MERCY HOSPITAL

Statement of Deficiencies and Plan of Corrections

This inspection was conducted at the request of Mercy Hospital. This is not a Federal Health Care Survey. The building is a five story Type I(332 construction.

Date of Inspection: 25 August 2008
Inspector: Jon Klages

Drawing Title and Number  
 GROUND FLOOR CODE  
 EGRESS AND LIFE SAFETY

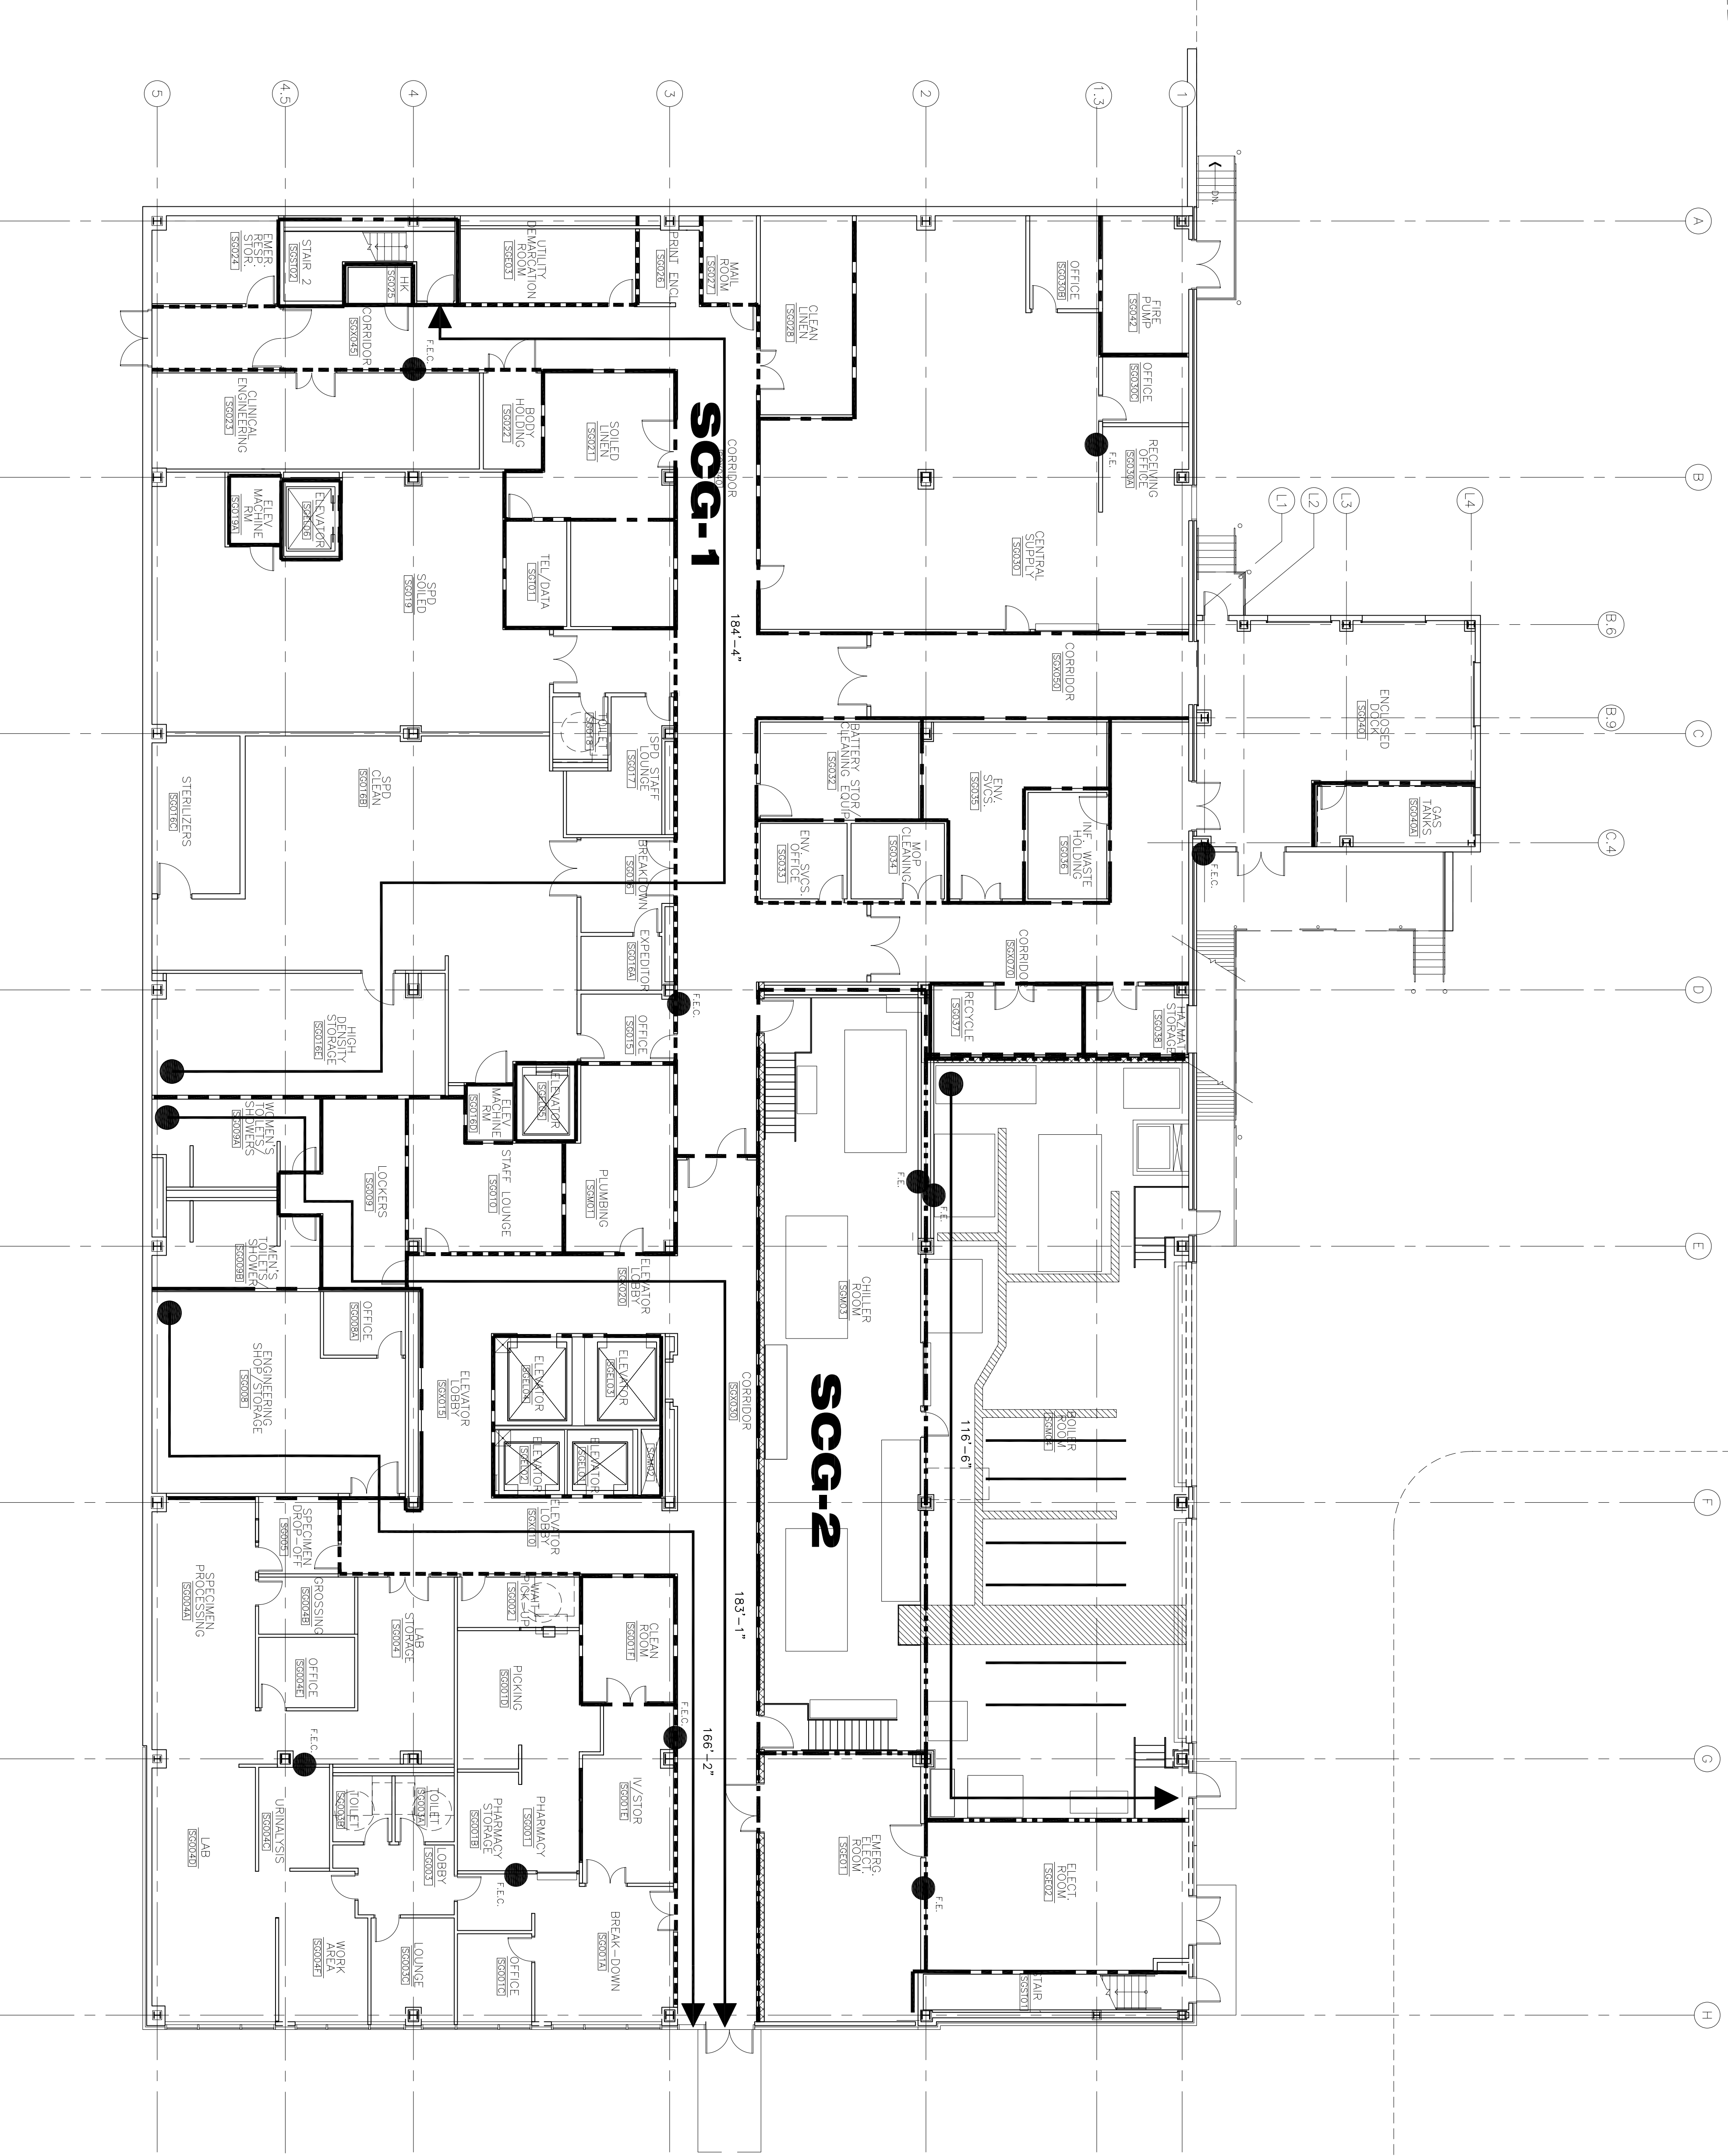
- 1. Room SGE-01 Repair sprinkler pipe penetration to corridor wall.
- 2. Stair well area at SSGST-101. Area under stairs must be sealed to retain two hour rating of stair tower.
- 3. Verify door rating to room SG-008. NOTE: This will be required for all piano type hinges on any rated door that is not clearly labeled.
- 4. Room SGM-01 repair fire proofing on steel structure above fire damper.

6. SG-040 Service air compressor is protruding into the exit door. Change exit door so the right side door has exit hardware and becomes the exit path. Mark the area to prevent buildup of storage that would block the door.

7. Fire Pump room GG-042 repair sprinkler pipe penetrations in wall to Central supply

- A. GELBANE WILL SEND TO FM OFFICE ON 9/2/2008
- B. PANELS WILL BE LABELED BY 9/2/2008
- C. GELBANE WILL SEND TO FM OFFICE ON 9/2/2008
- D. GELBANE WILL SEND THIS TO THE FIRE MARSHAL OFFICE BY 9/21/2008
- E. GELBANE WILL SEND TO FM OFFICE ON 9/2/2008.
- 1. THIS ITEM HAS BEEN COMPLETED.
- 2. THIS ITEM HAS BEEN COMPLETED.
- 3. ALL FIRE RATED DOORS WILL BE TAGGED BY 9/21/2008
- 4. THIS ITEM HAS BEEN COMPLETED.

6. DOORS WILL BE REPLACED BY 10/26/2008. FLOOR WILL BE MARKED BY 10/26/2008.

7. THIS ITEM HAS BEEN COMPLETED.

Drawing Title and Number:
 FIRST FLOOR CODE EGRESS AND
 LIFE SAFETY PLAN
A0.01

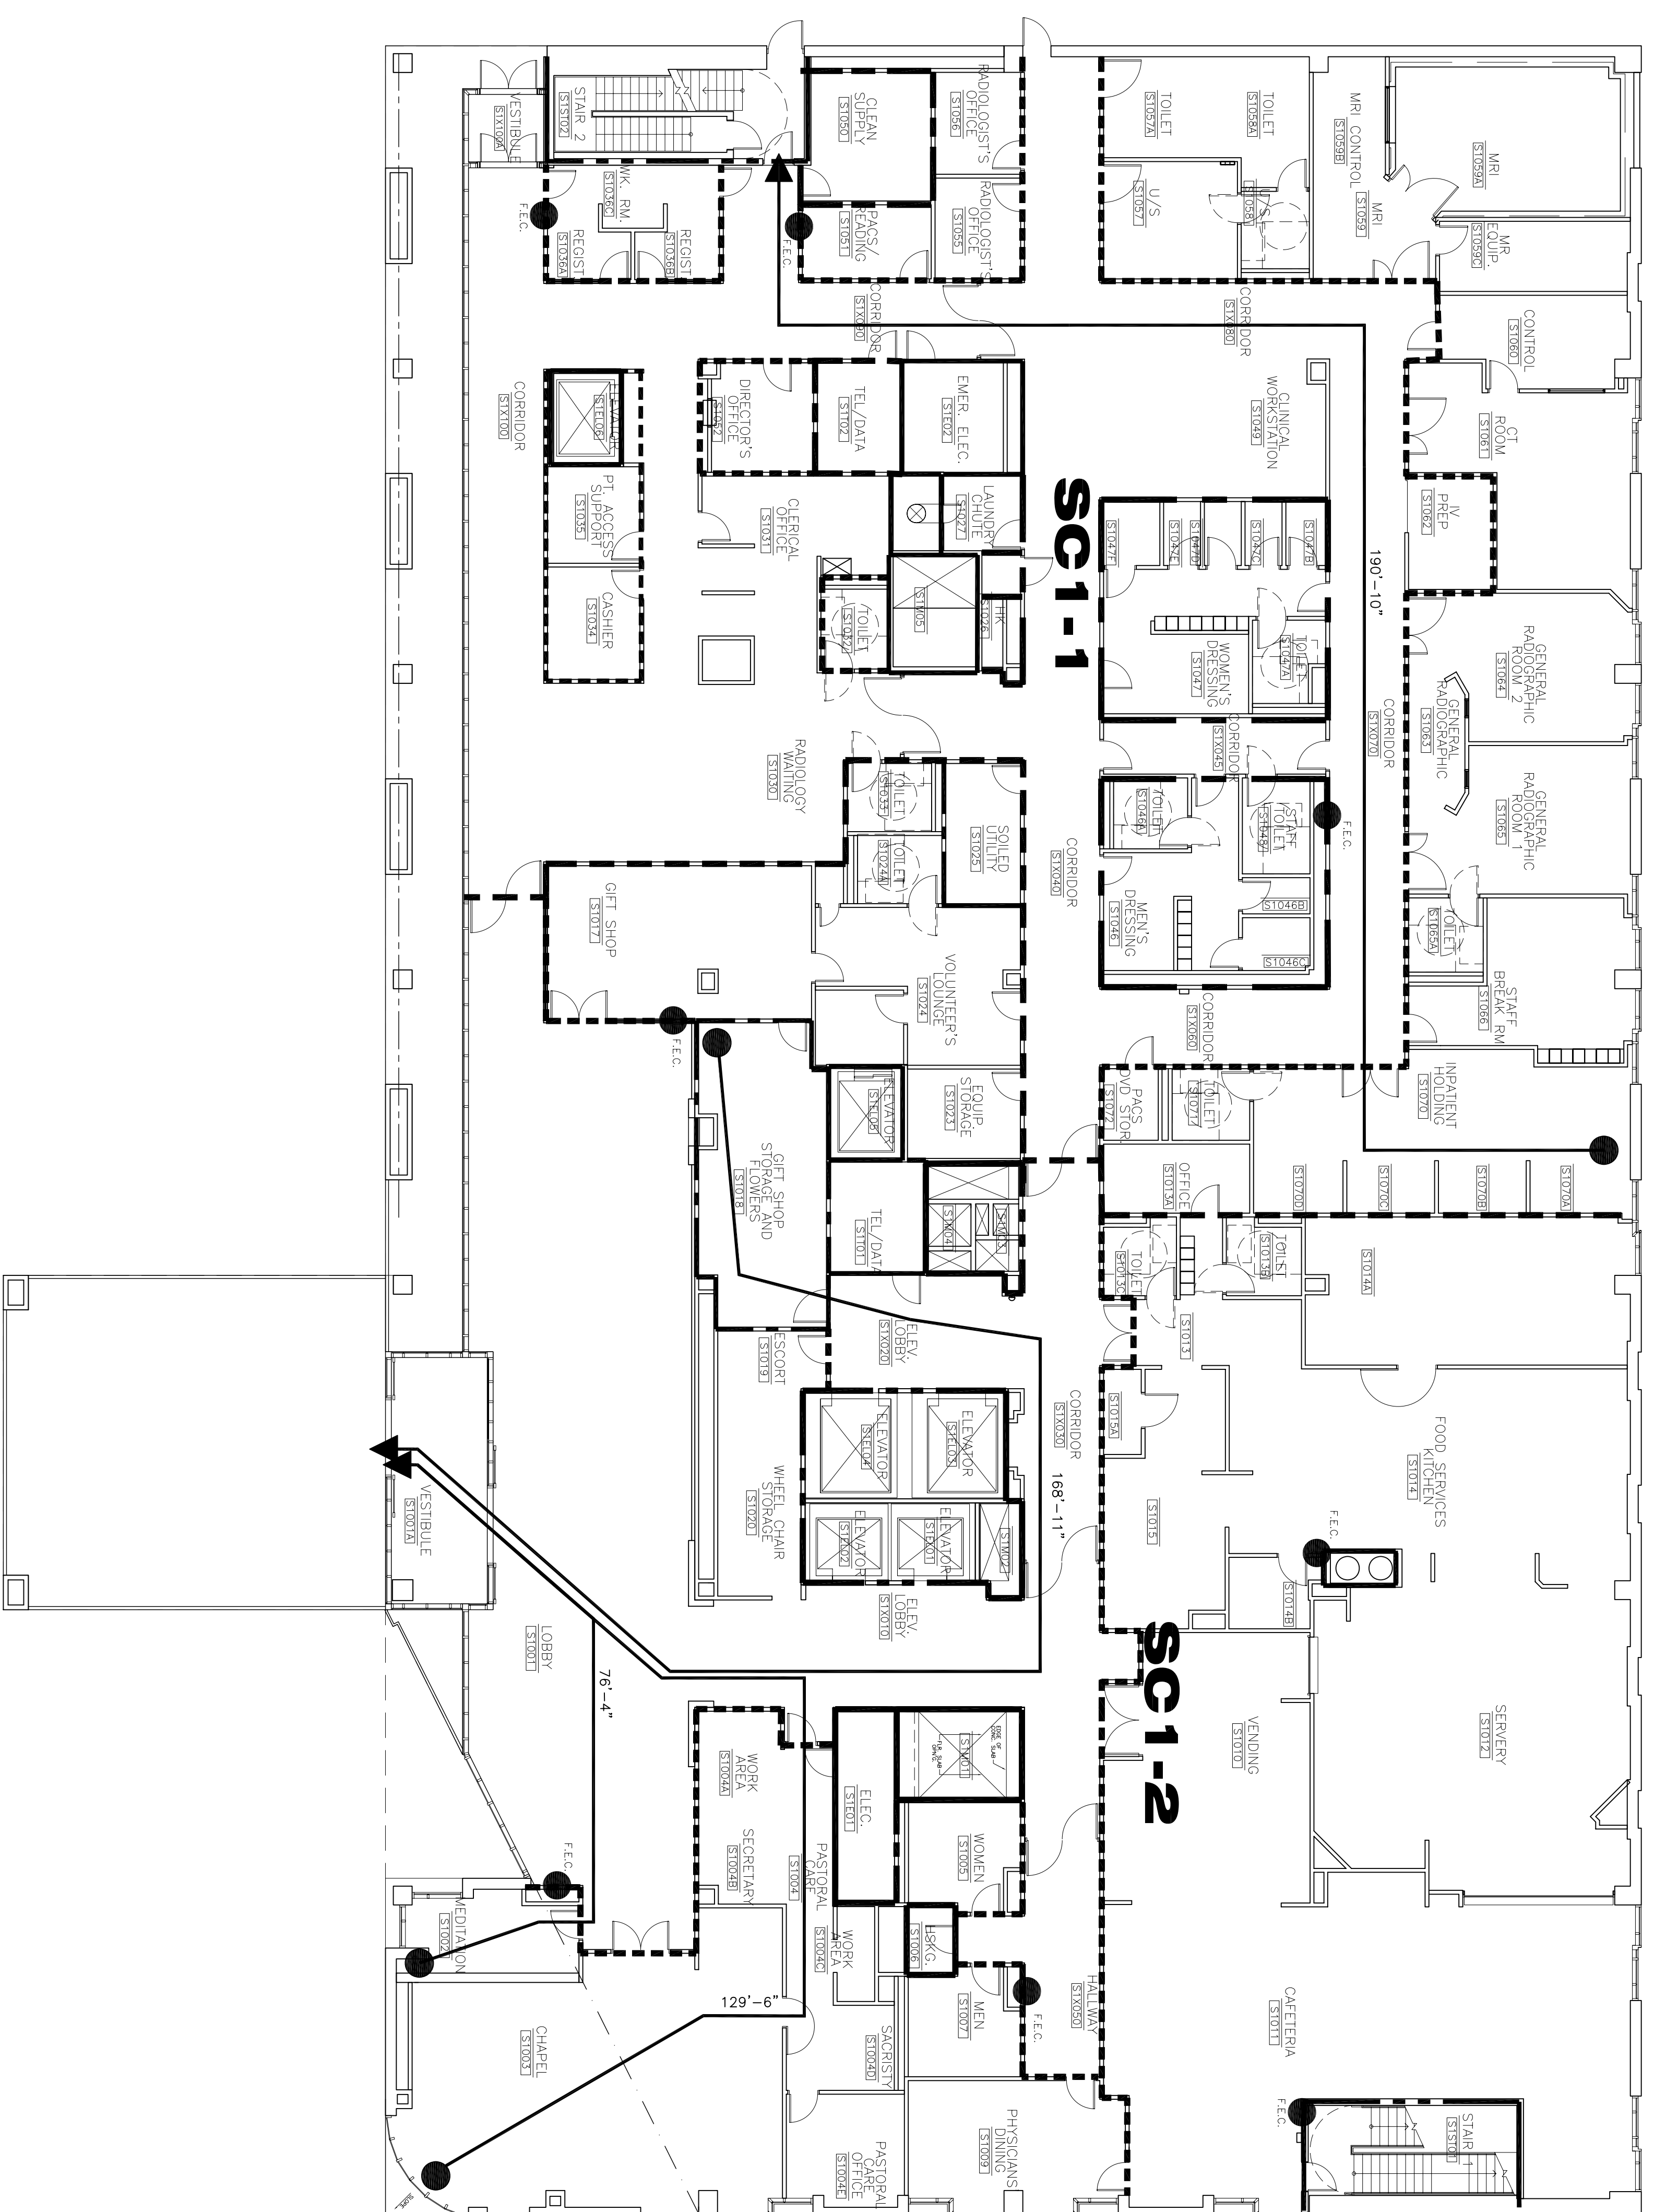
1. Adjust smoke door SIX100 to close and latch
2. S1-001 (main Lobby) Remove or disconnect gas from non-vented fuel fired heater. This is per Chapter 20 of State Fire Marshal Rules.
3. S1E-01 Repair penetrations to corridor
4. Stair one first floor landing repair sprinkler penetration S1ST01
5. S1-E02 Rate wall behind electrical conduit
6. Repair shaft access to smoke damper in corridor ~~S1X0440~~ S1X040
7. Stair two first floor S1ST02 repair pipe penetrations
8. Repair penetrations in rooms; 2047, 2045, and 2032, 2019.

9. IV preparation room must have smoke detection or a door separating it from the corridor. If the use of the space involves treatment then a door will be required.

1. THIS ITEM HAS BEEN COMPLETED.

2. THIS ITEM HAS BEEN COMPLETED.

3. THIS ITEM HAS BEEN COMPLETED.

4. THIS ITEM HAS BEEN COMPLETED.

5. THIS ITEM WILL BE COMPLETED BY 7/5/2008

6. THIS ITEM HAS BEEN COMPLETED.

7. THIS ITEM HAS BEEN COMPLETED.

8. THIS ITEM HAS BEEN COMPLETED.

9. THIS ITEM WILL BE COMPLETED BY 9/21/2008.
